Application no: H19-0552-10

Description: Extensions and alterations to dwelling, erection of detached triple garage and change of use of existing business unit into residential annexe

Location: Station House
French Drove
Gedney Hill
Spalding Lincs
PE12 0NR
PE12 0NR

ACKNOWLEDGEMENT OF AMENDMENT

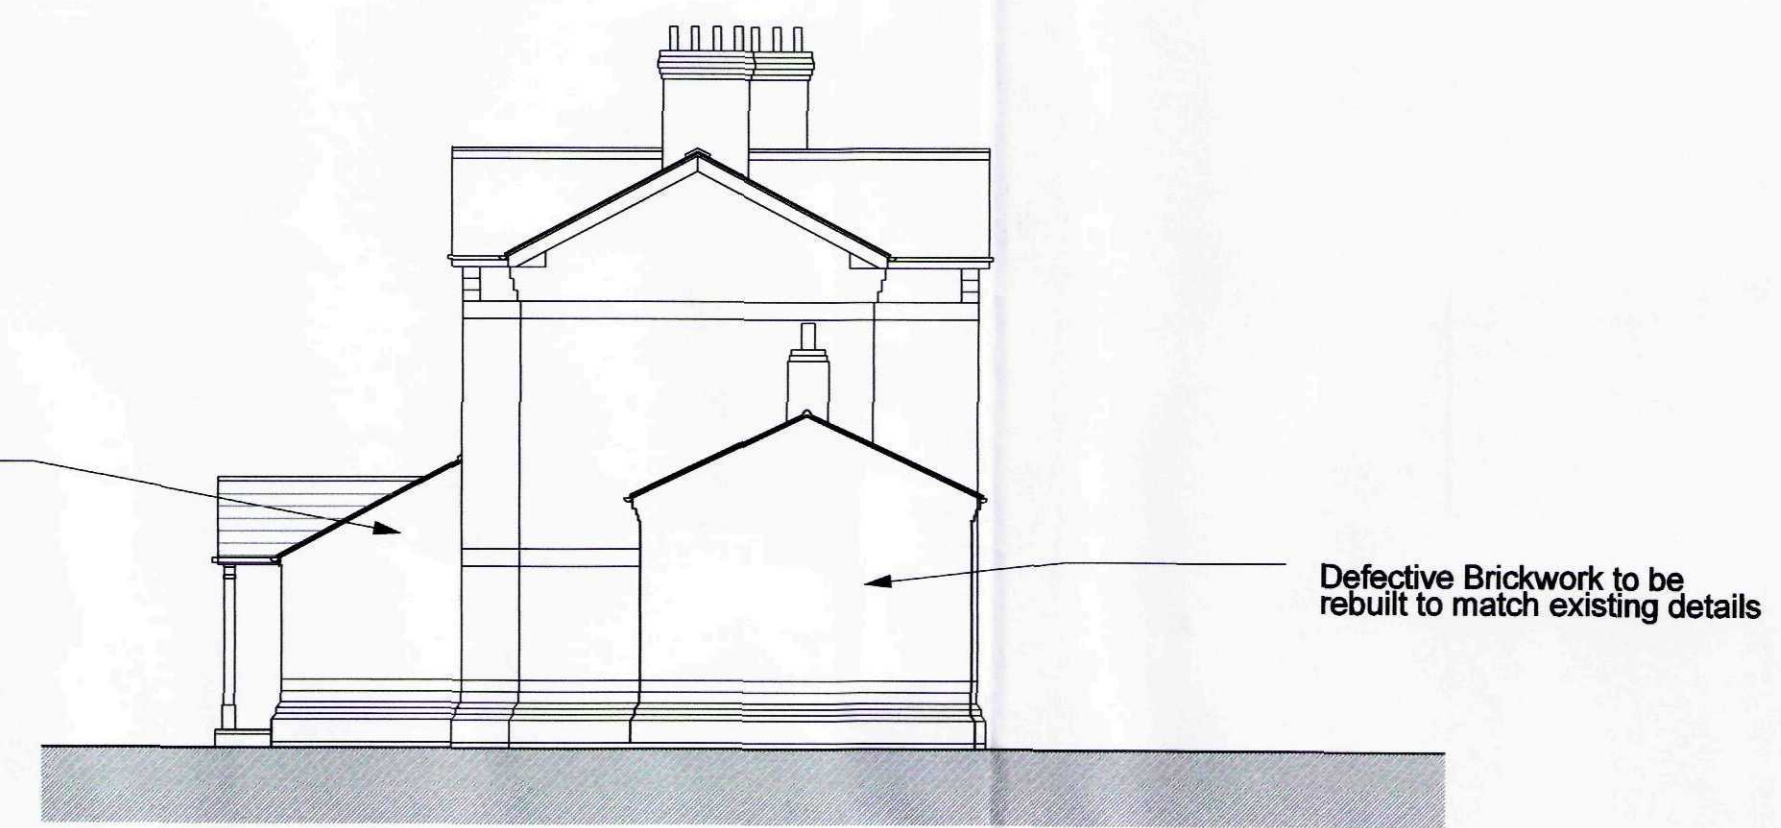
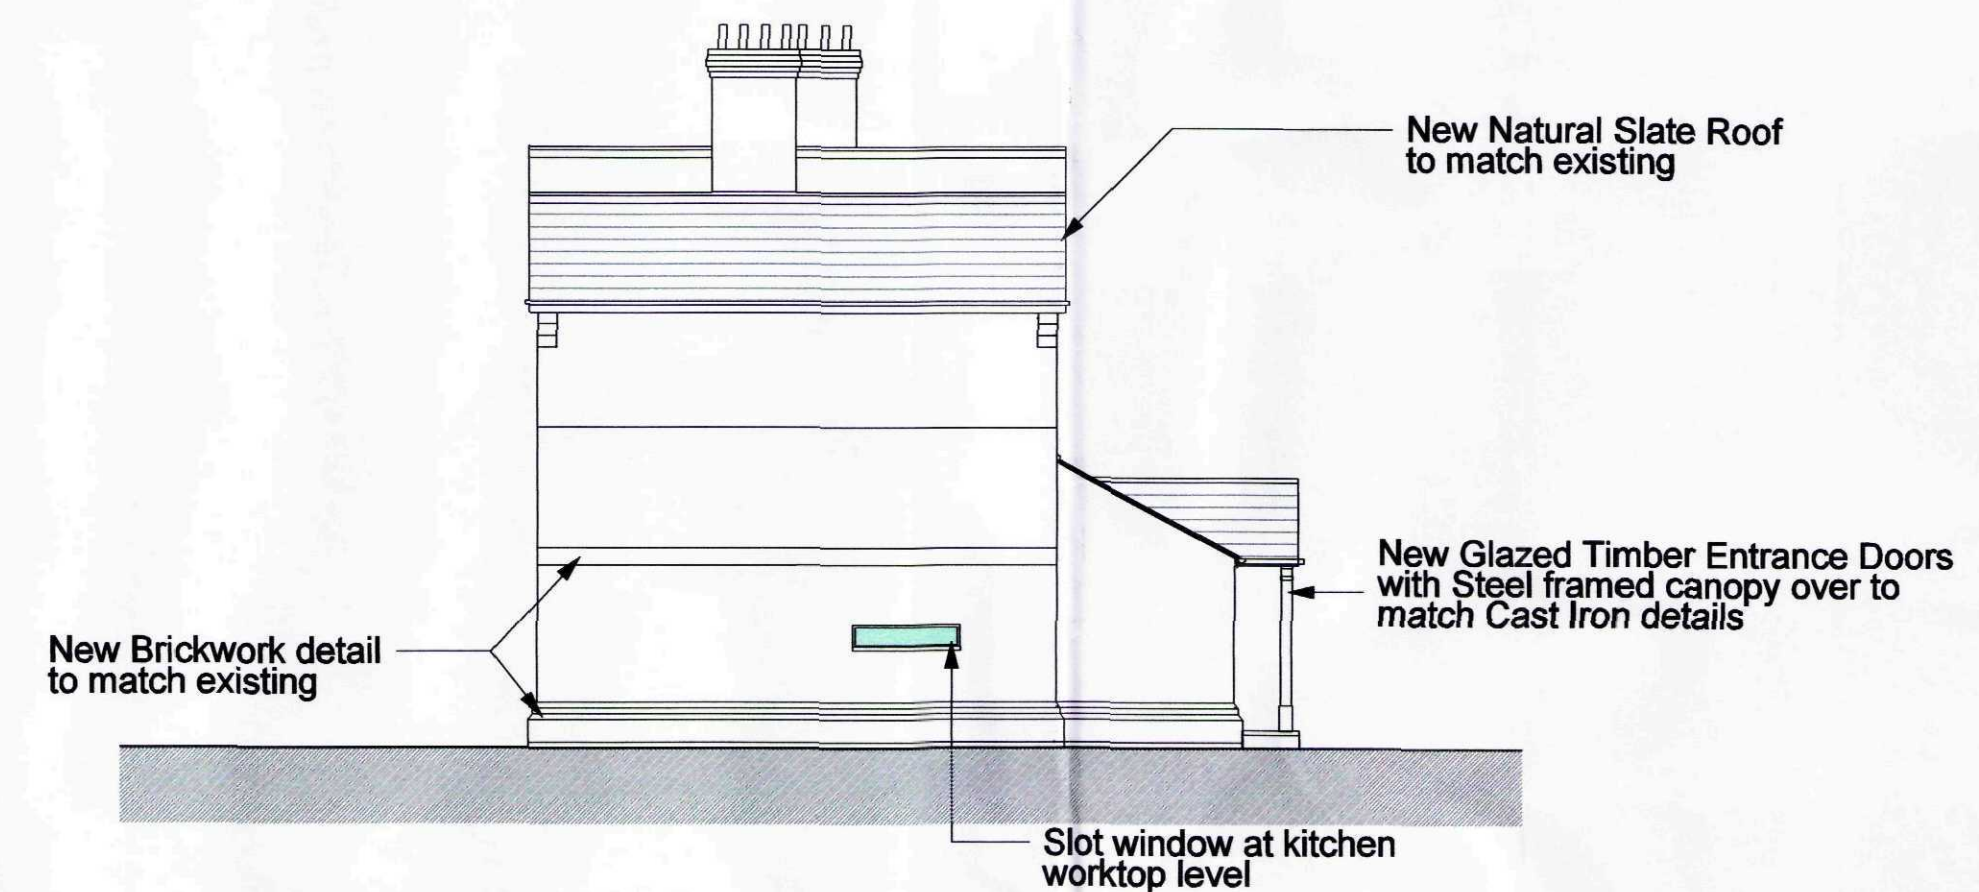
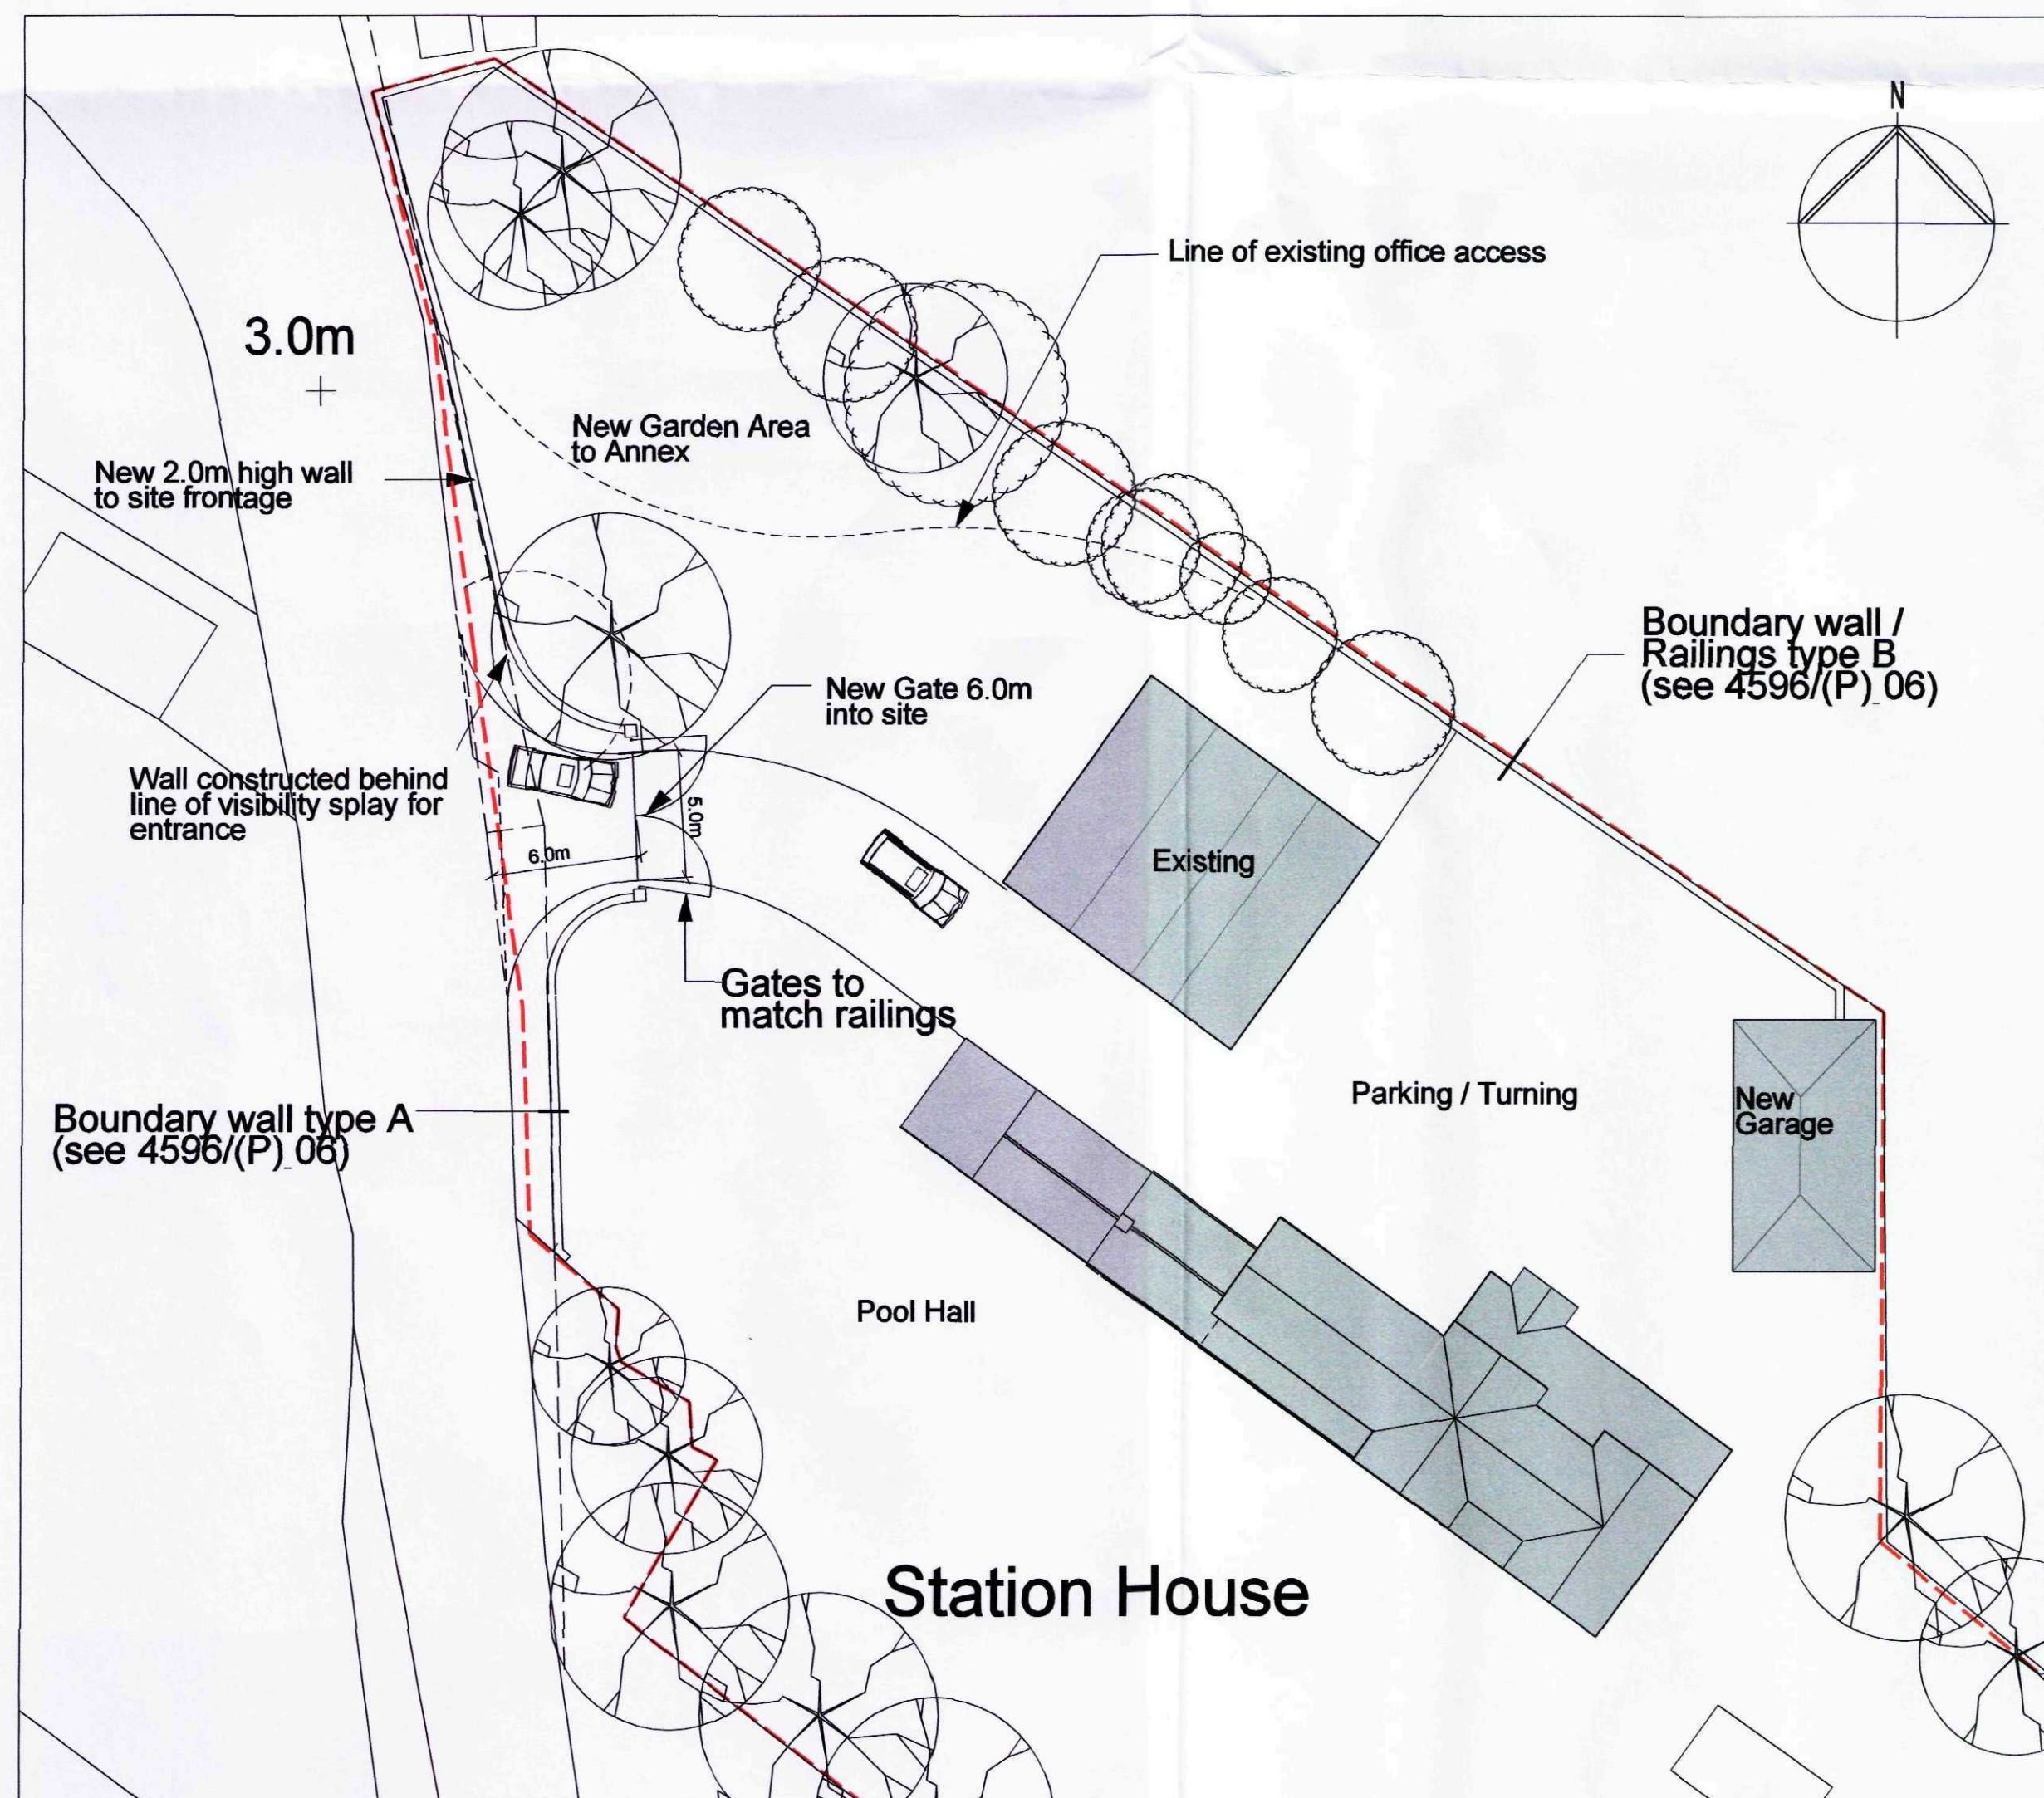
Amendment: Reduce two-storey extension at southeast, omit pool enclosure & assoc. works to single-storey at northwest

Following our recent exchange of e-mails and telephone conversation I would confirm that we have now discussed the issue with our client, who has instructed us to amend the scheme on the lines discussed with you. We have therefore prepared revised drawings 4596/(P)_01_A and /(P)_02_A which have the revised and reduced two story extension at the South East end of the building. The proposals shown also omit the proposed pool enclosure and the associated works to the single storey elements at the North West end of the structure, which were felt to be out of character with the structure.
